# CITY OF ALBUQUERQUE

August 8, 2018

**Re: McDonald's**  
**5001 Gibson Blvd SE**  
**30-Day Temporary Certificate of Occupancy-Transportation Development**  
**Transportation Development Final Inspection**  
Engineer's/Architect's Stamp dated 01-09-18 (L18D053)  
Certification dated 07-31-18

TRAFFIC CIRCULATION PLAN

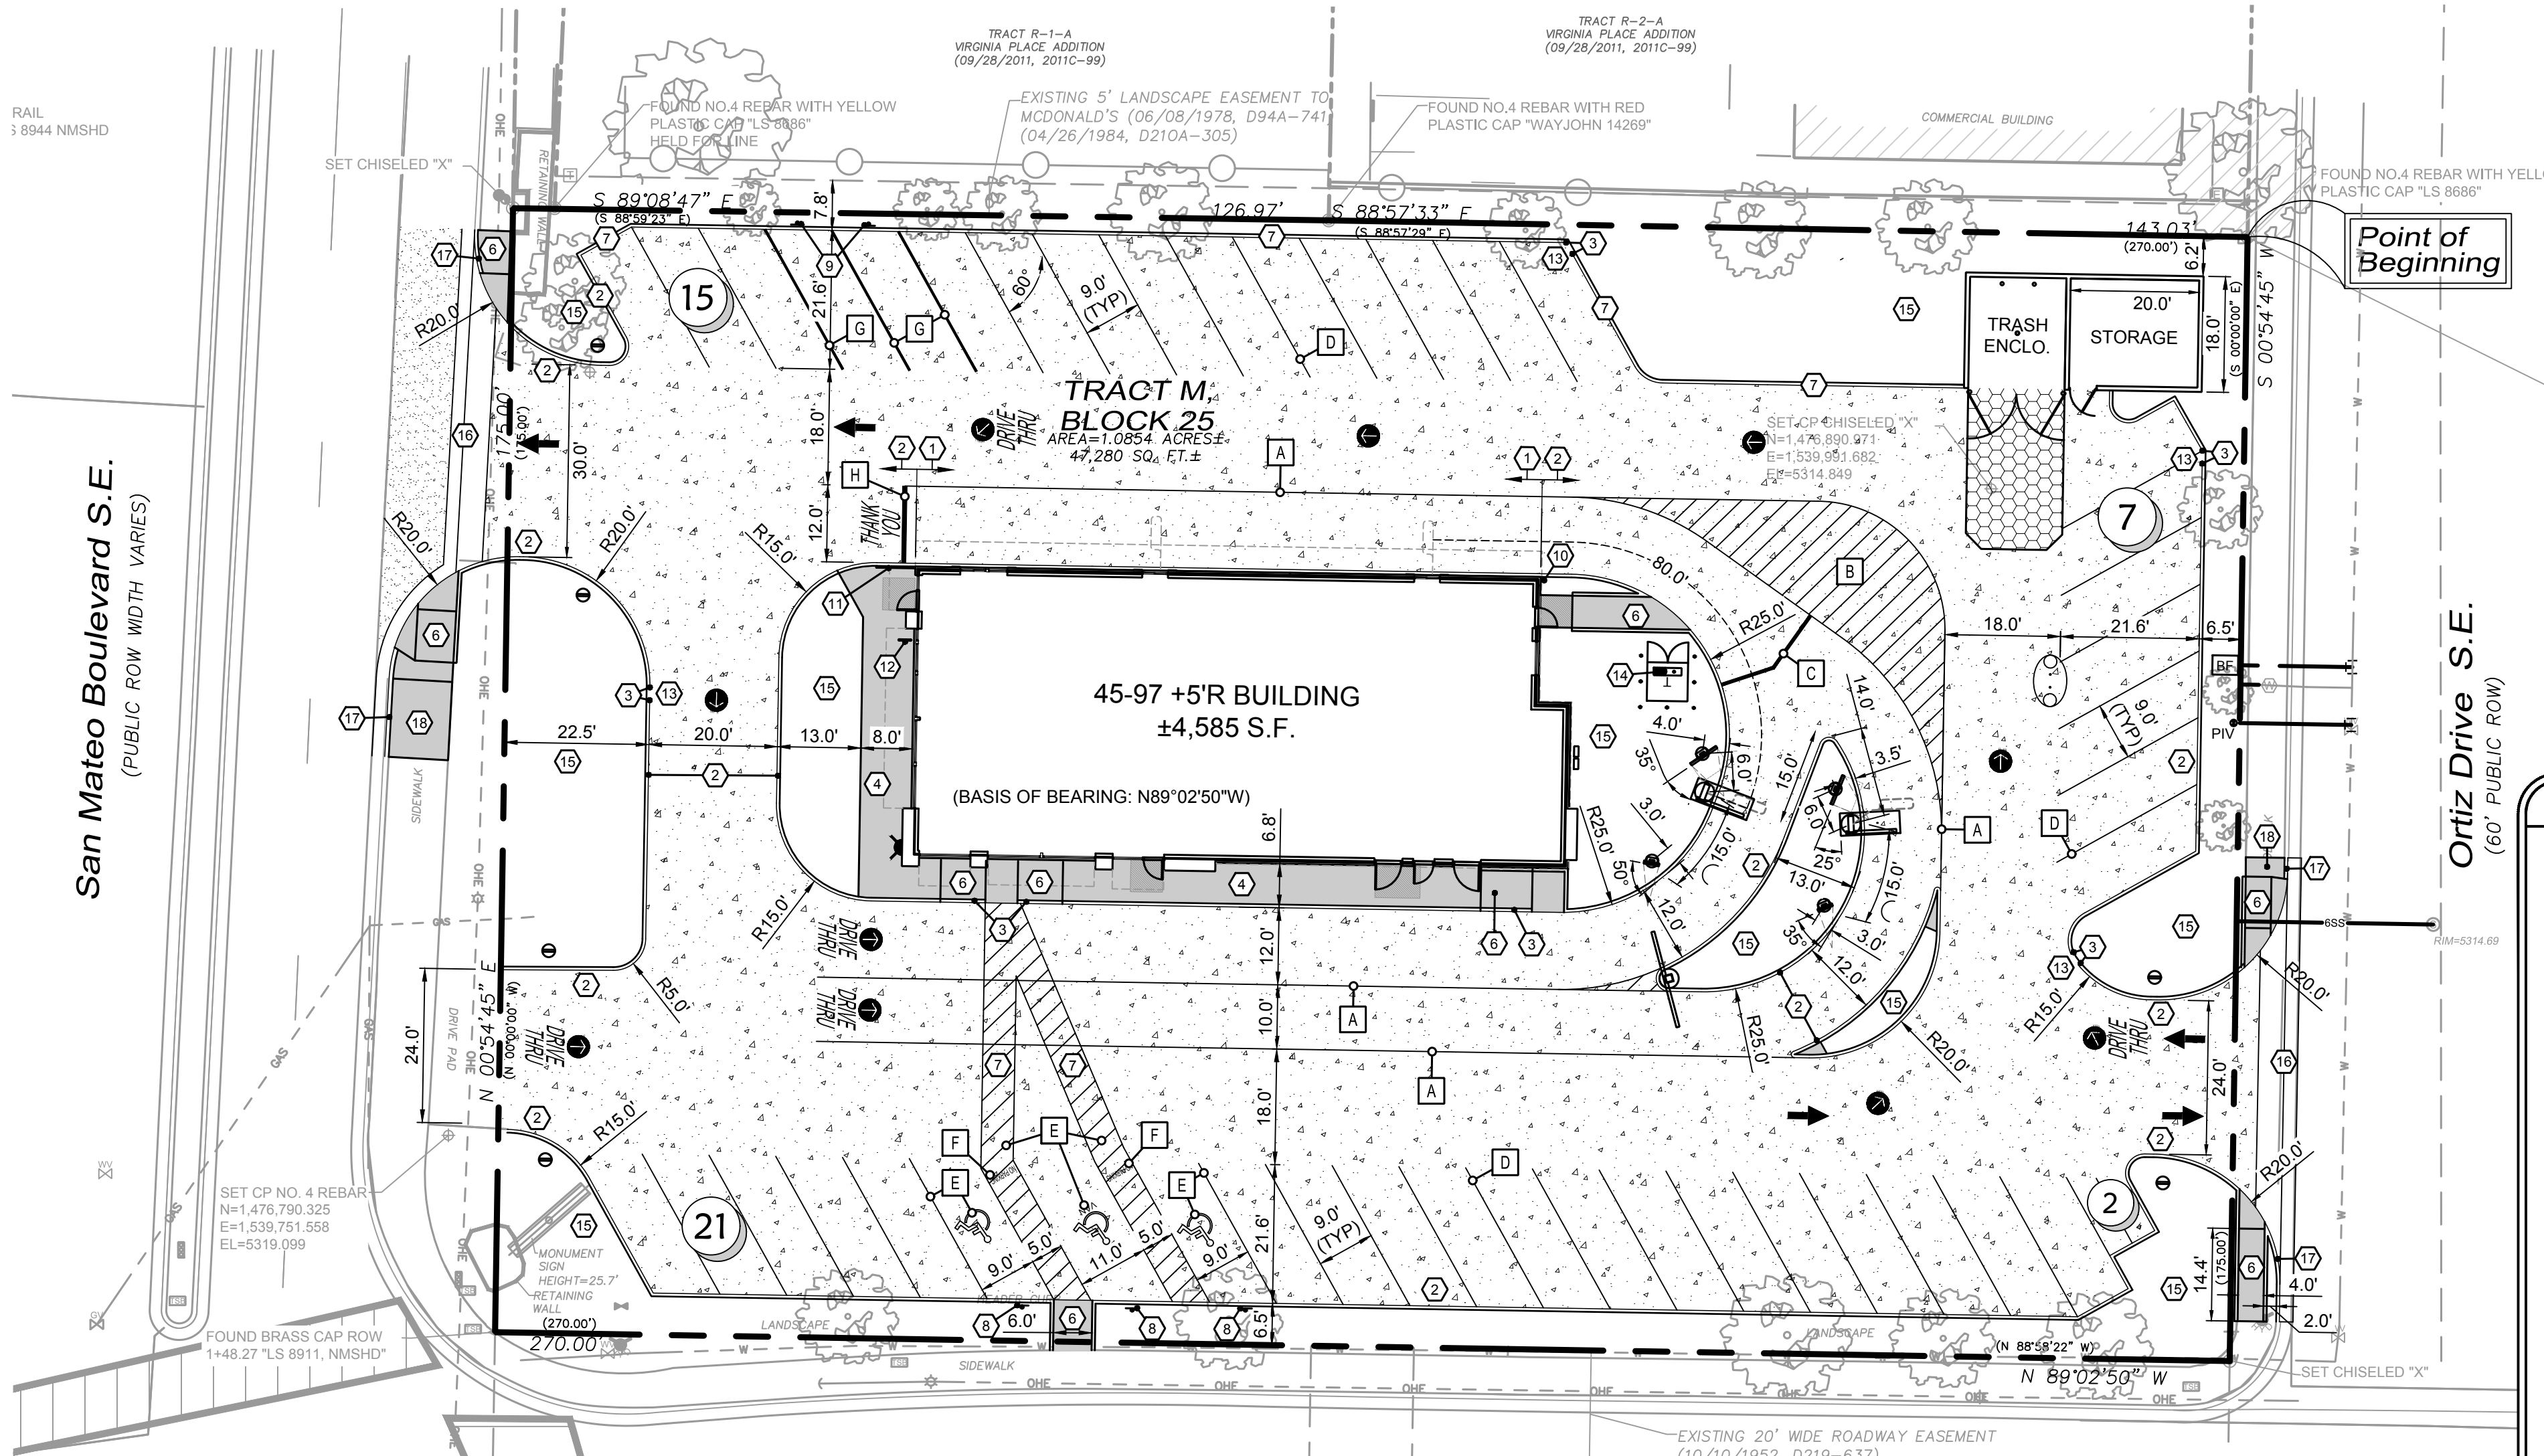
1. Please add Motorcycle parking signs & McDonalds OOSP Sign.
2. Please add NO Parking in the ADA access aisle.
